RE: **Dunkin' Donuts**
4208 Central SW
Grading Plan Stamp Date: 7/16/19
Hydrology File: K12D015D

Based on the submittal received on 7/16/19, this project cannot be approved until the following corrections are made:

Grading Plan

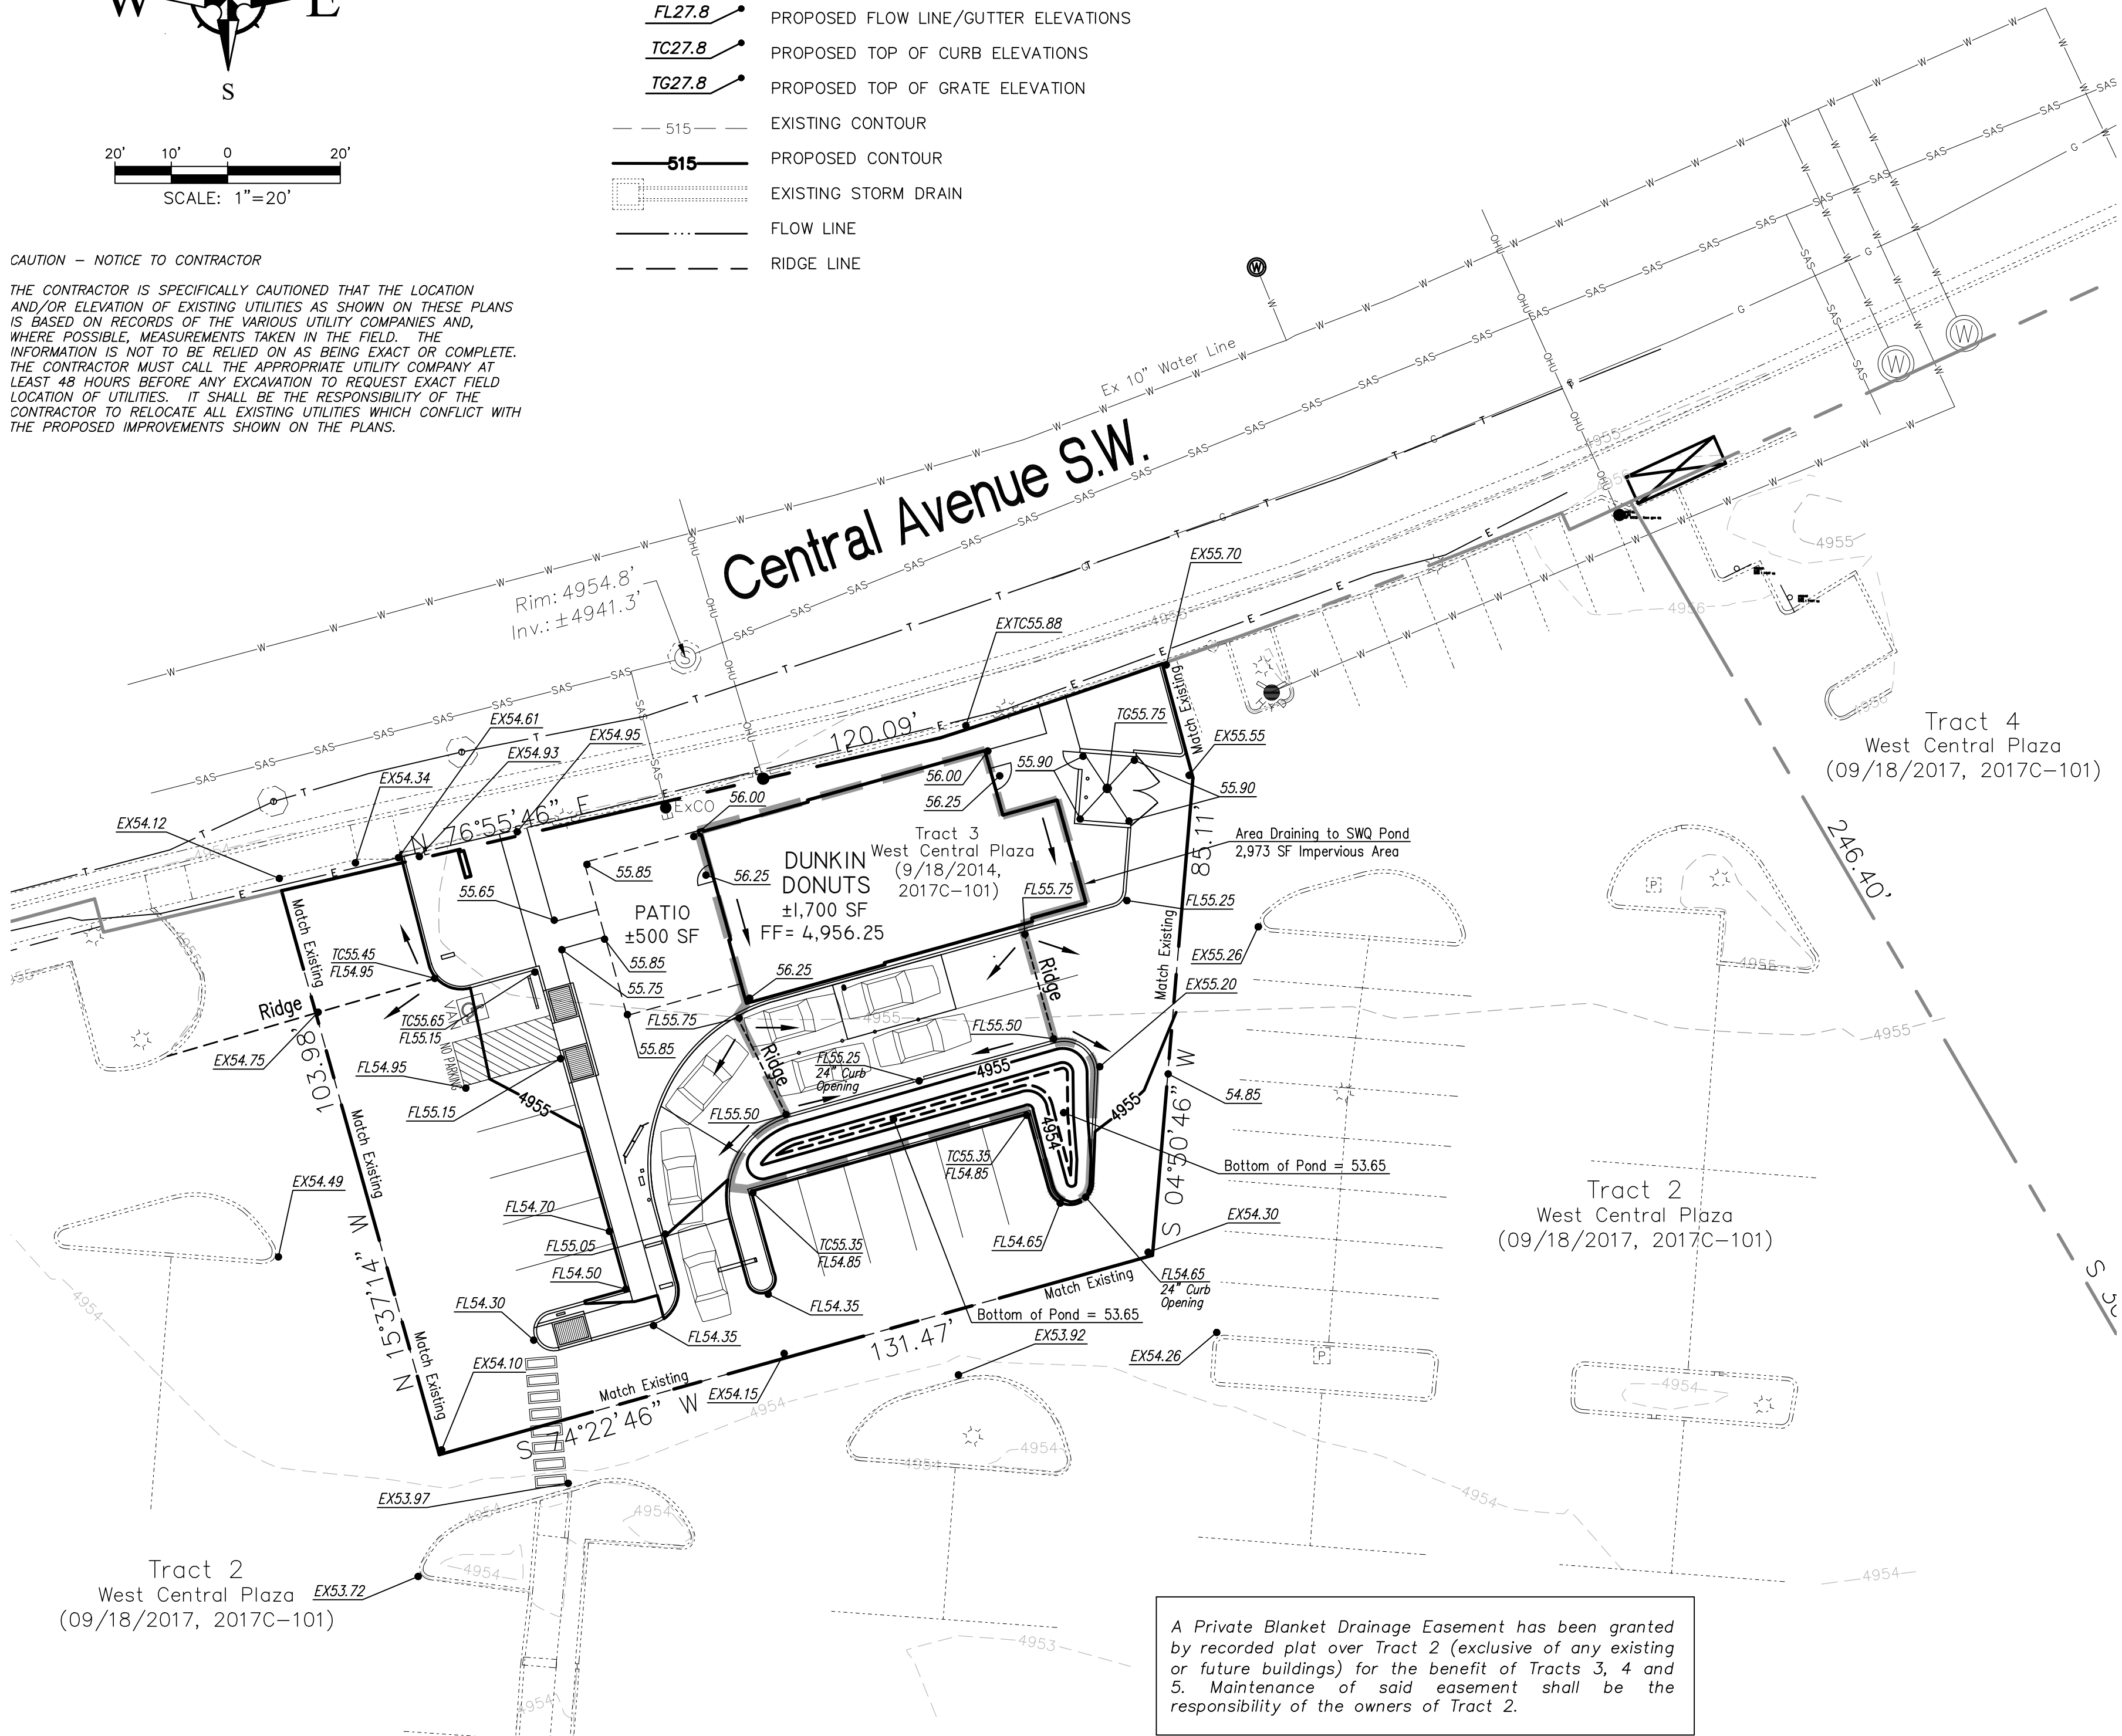
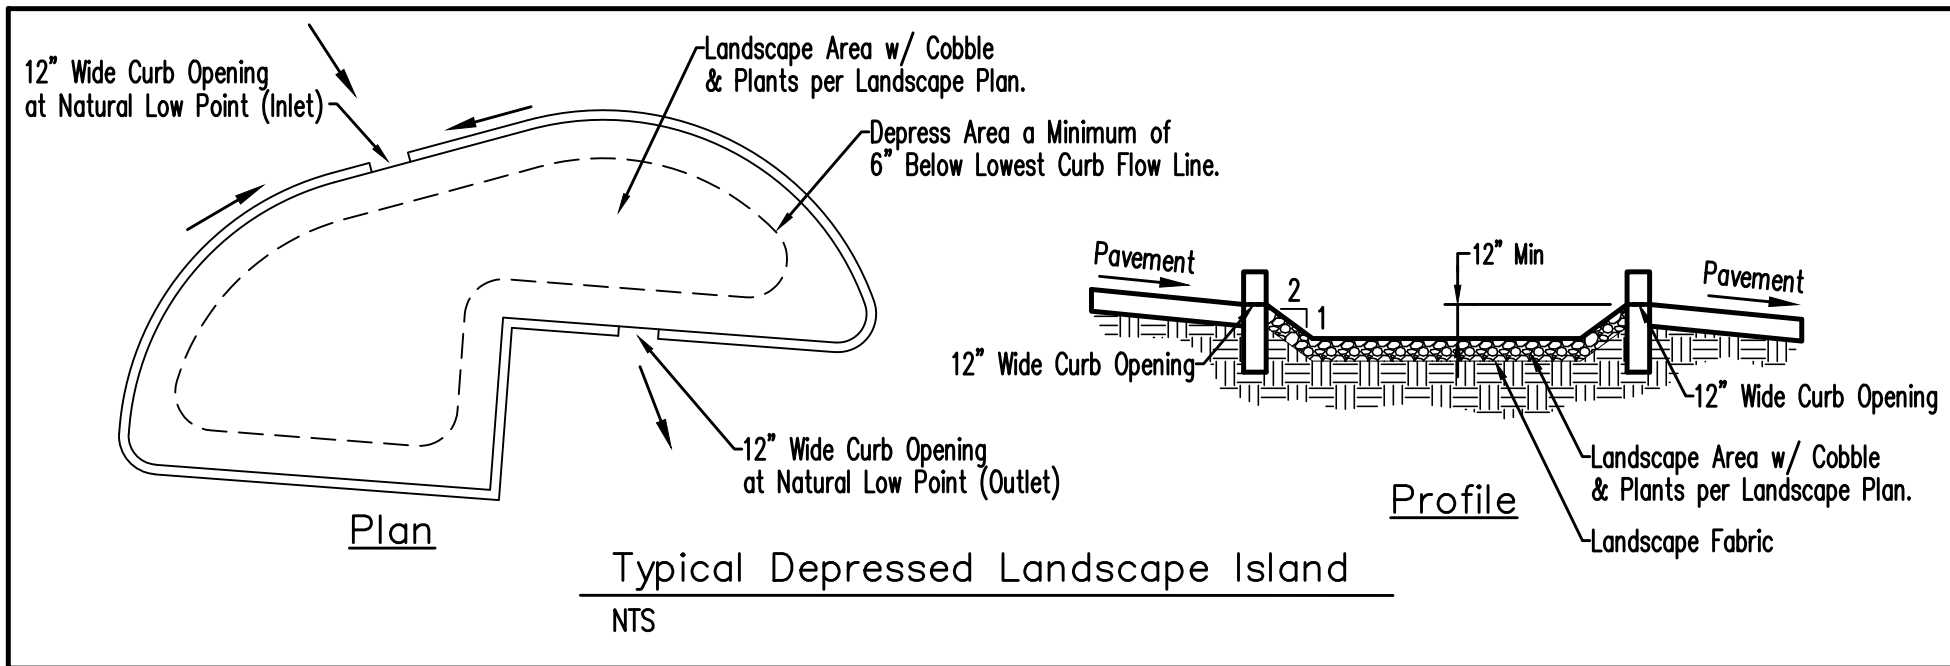
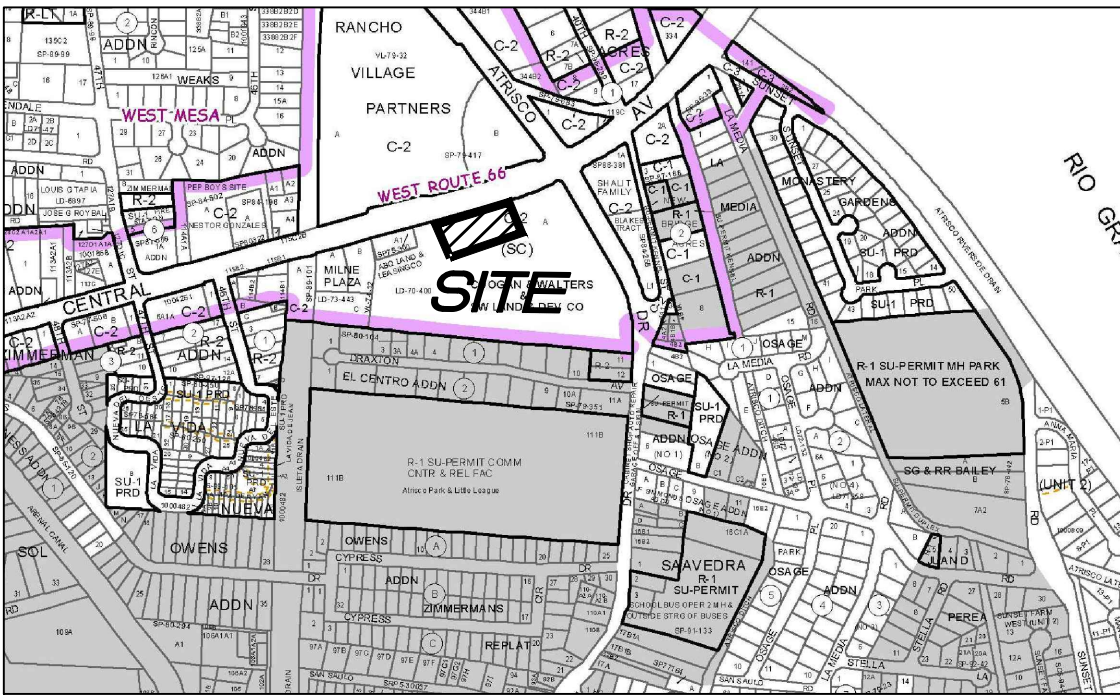
1. The Stormwater Quality (SWQ) bypass volume needs to be calculated. Determine the impervious area draining to your new island pond and deduct from the total SWQ volume requirement for this project.

2. The total SWQV requirement should be determined from the area of redeveloped impervious. If you have existing asphalt to remain, it should be deducted from the requirement.

3. Payment in Lieu (Amount = TBD) of onsite management of the SWQ bypass volume must be made. Unfortunately, the previous plan from 2015 does not adequately treat the SWQV for this site, as it drains to the onsite storm drain and out the Atrisco Drain, bypassing the various ponds in the development.

4. For trash enclosures serving food service developments, demonstrate *control of liquids from dumpster areas* per DPM Chapter 22.9.E, Table 1 by: containing runoff from the dumpster area, preventing outside drainage from entering the dumpster area, and discharging to the sanitary sewer. If this information is on the utility plan please provide it, or show on the grading plan.
